# Rezoning Transportation Analysis

Petition Number: 2023-091

**From:** Jake Carpenter, PE

## Revision Log:

SCHEMATIC SITE PLAN

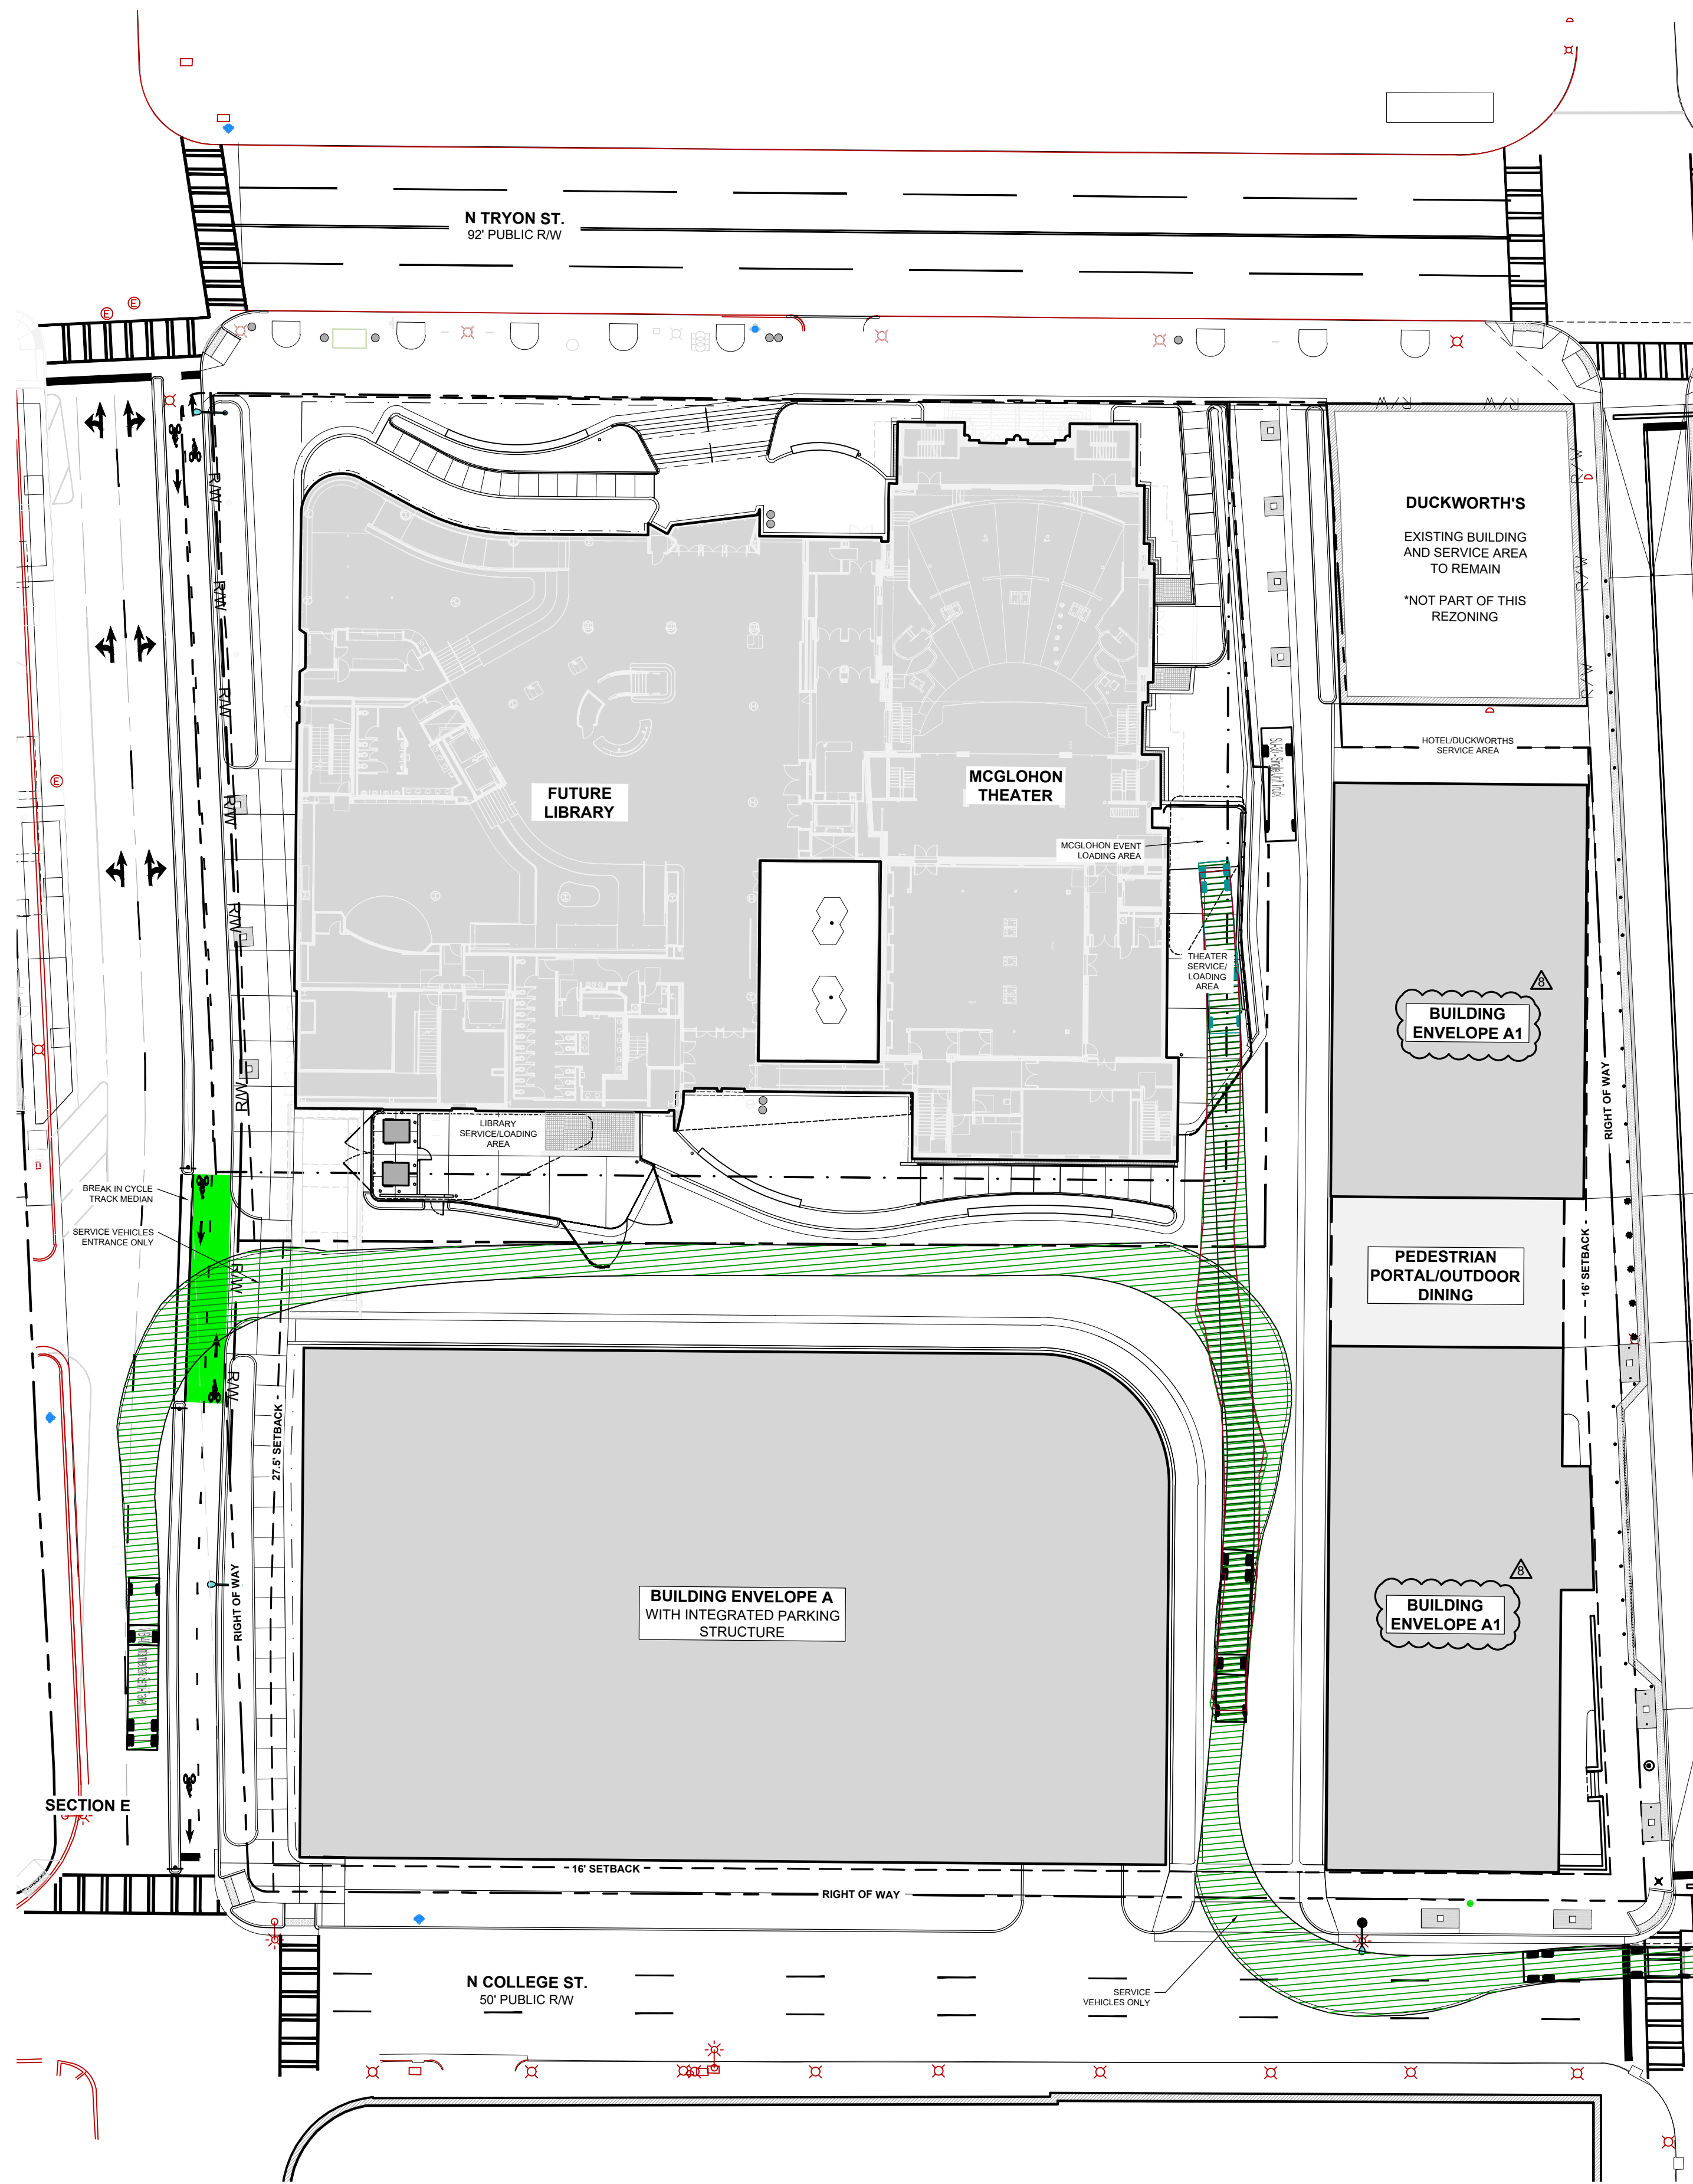
- ~~3. Revise site plan and conditional note(s) to commit to dedicate right of way from the road centerline to 2' behind the shared use path. The site plan shall label and dimension the right of way from the road centerline.~~

~~Clarifying Comment 10.26.23: Either dedicate ROW or provide a sidewalk utility easement. SUE should be placed 2' behind the back of walk, or at the face of building where 2' cannot be obtained.~~

- ~~4. Revise site plan and conditional note(s) to commit to construct bicycle facilities by installing a 10' multi-use path along East 6<sup>th</sup> street, North College Street, and East 7<sup>th</sup> Street. in accordance with the council-adopted Charlotte Streets Map. Multi-use paths maintained by the City shall meet ADA/PROWAG requirements.~~

- ~~5. Revise site plan and conditional note(s) to commit to construct bicycle facilities by installing a 12' multi-use path along North Tryon Street in accordance with the council-adopted Charlotte Streets Map. Multi-use paths maintained by the City shall meet ADA/PROWAG requirements.~~

- ~~6. Per City of Charlotte Sight Distance Policy and Charlotte UDO, 10' x 10' pedestrian sight triangles will be required at all connections to the public roadway system.~~

- ~~7. **Outstanding Comment 10.26.23:** Add a conditional note specifying "the Petitioner shall dedicate and convey in fee simple all rights of way to the City before the site's first building certificate of occupancy is issued. CDOT requests rights of way set at 2' behind back of sidewalk where feasible."~~

2 - 6TH ST. STREET SECTION E

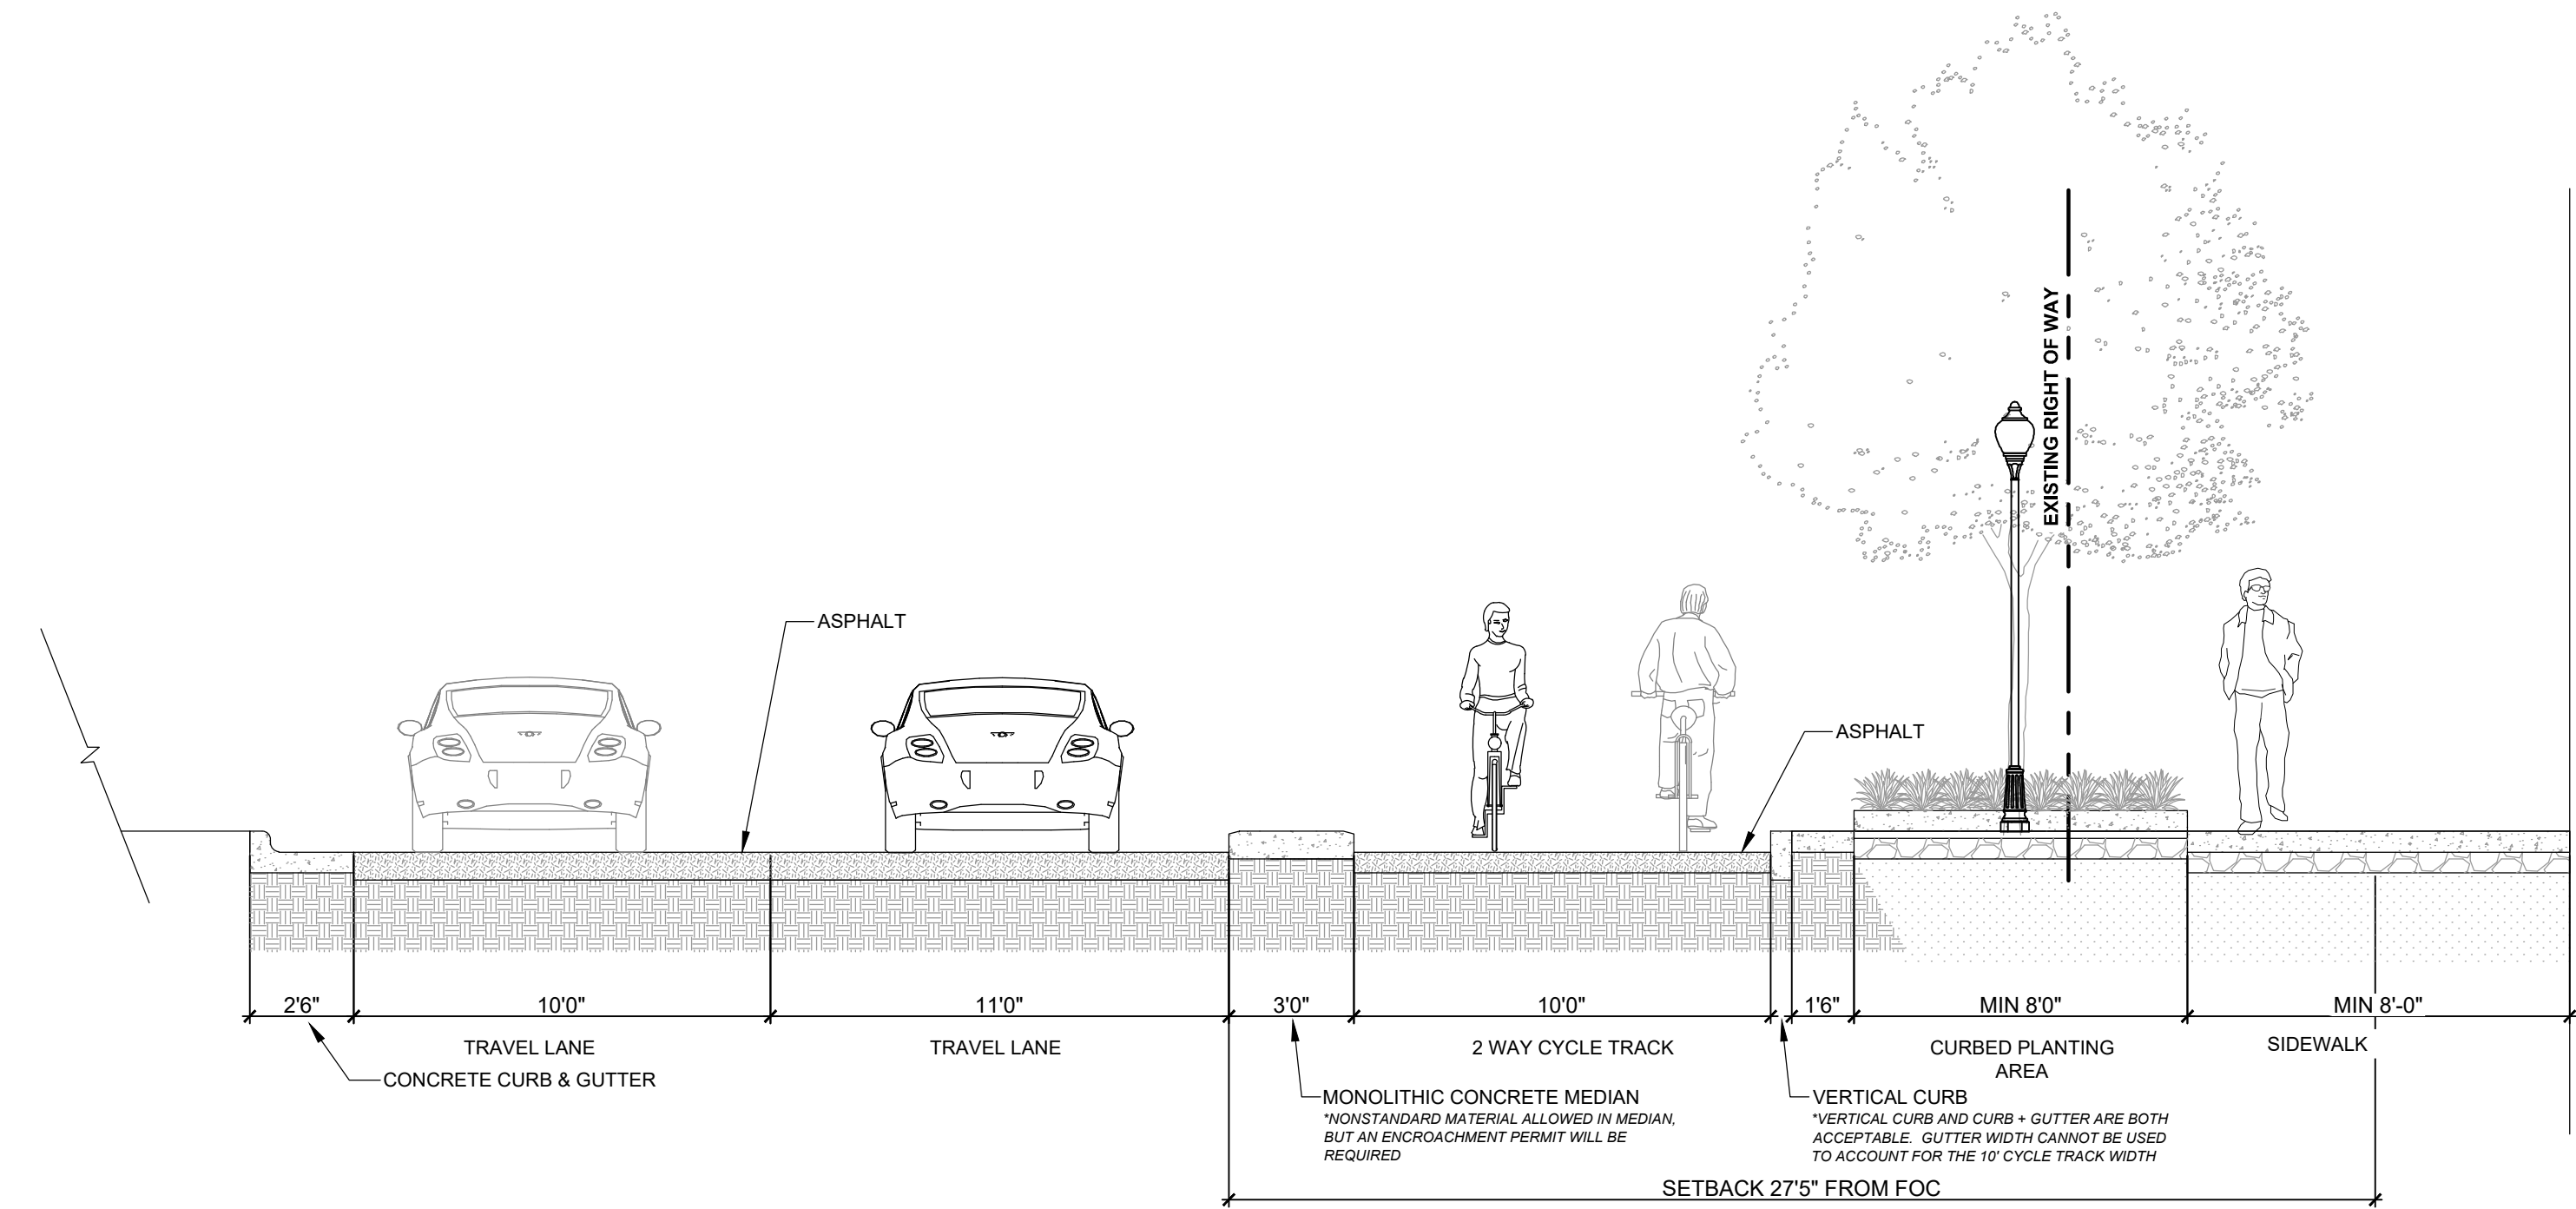
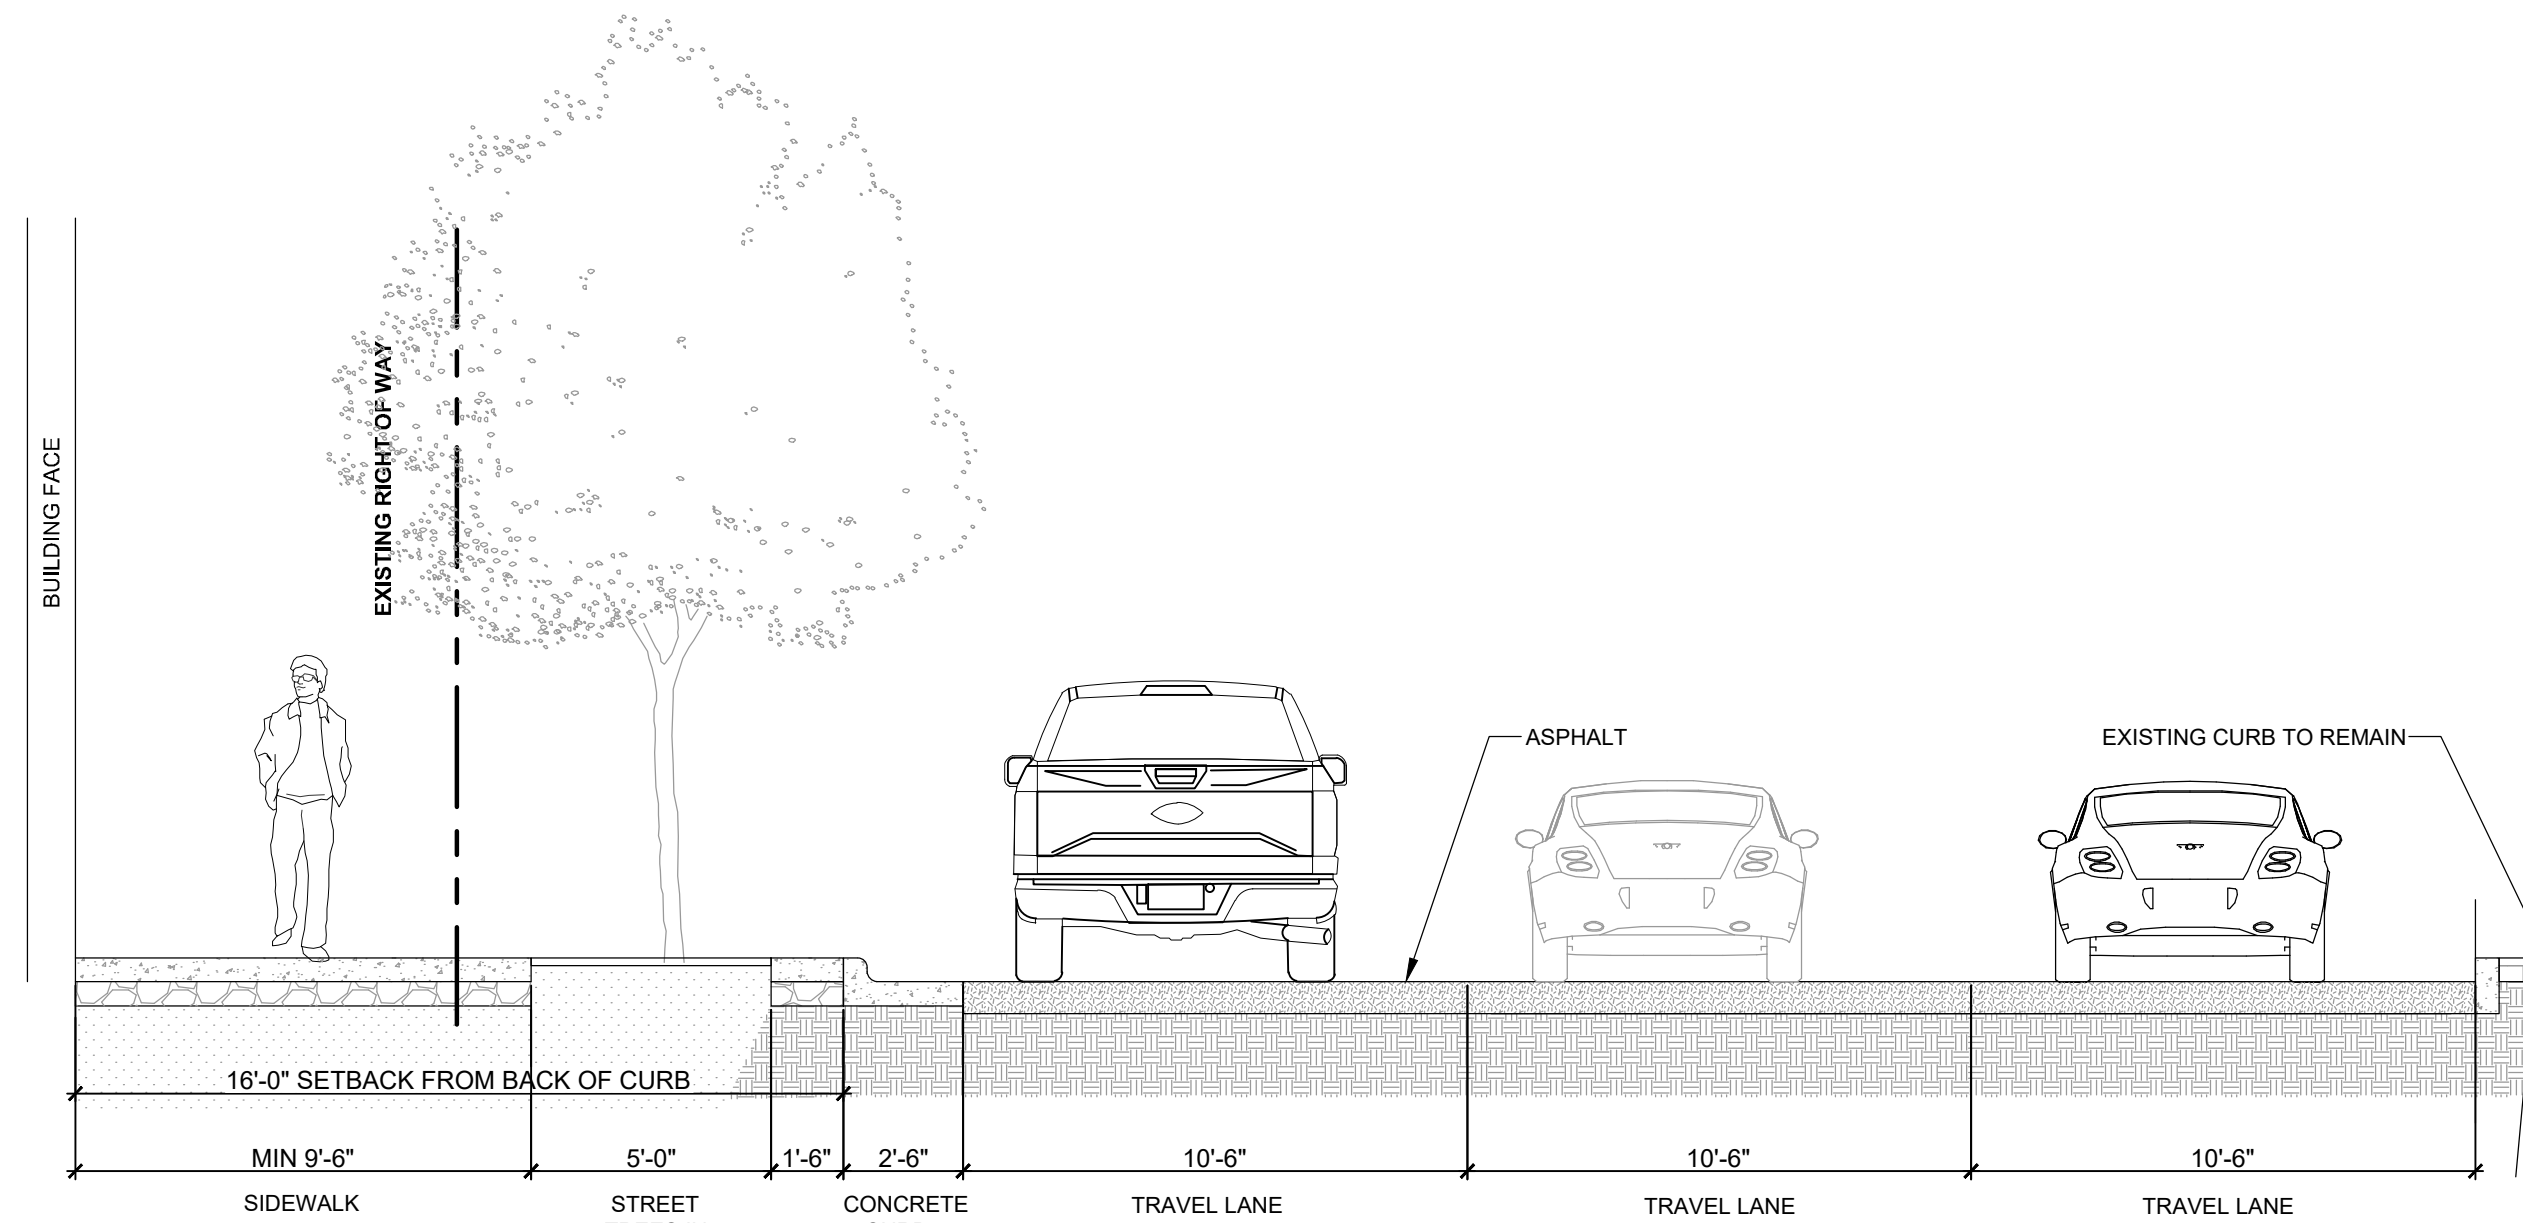
a. ~~East 6<sup>th</sup> Street:~~ The future location of curb and gutter is in its existing location.

~~This street is an uptown primary street, and the cross section requires a 10' shared use path with an 8' amenity zone.~~

~~Label and dimension the curb and gutter from the centerline for each road on the site plan.~~
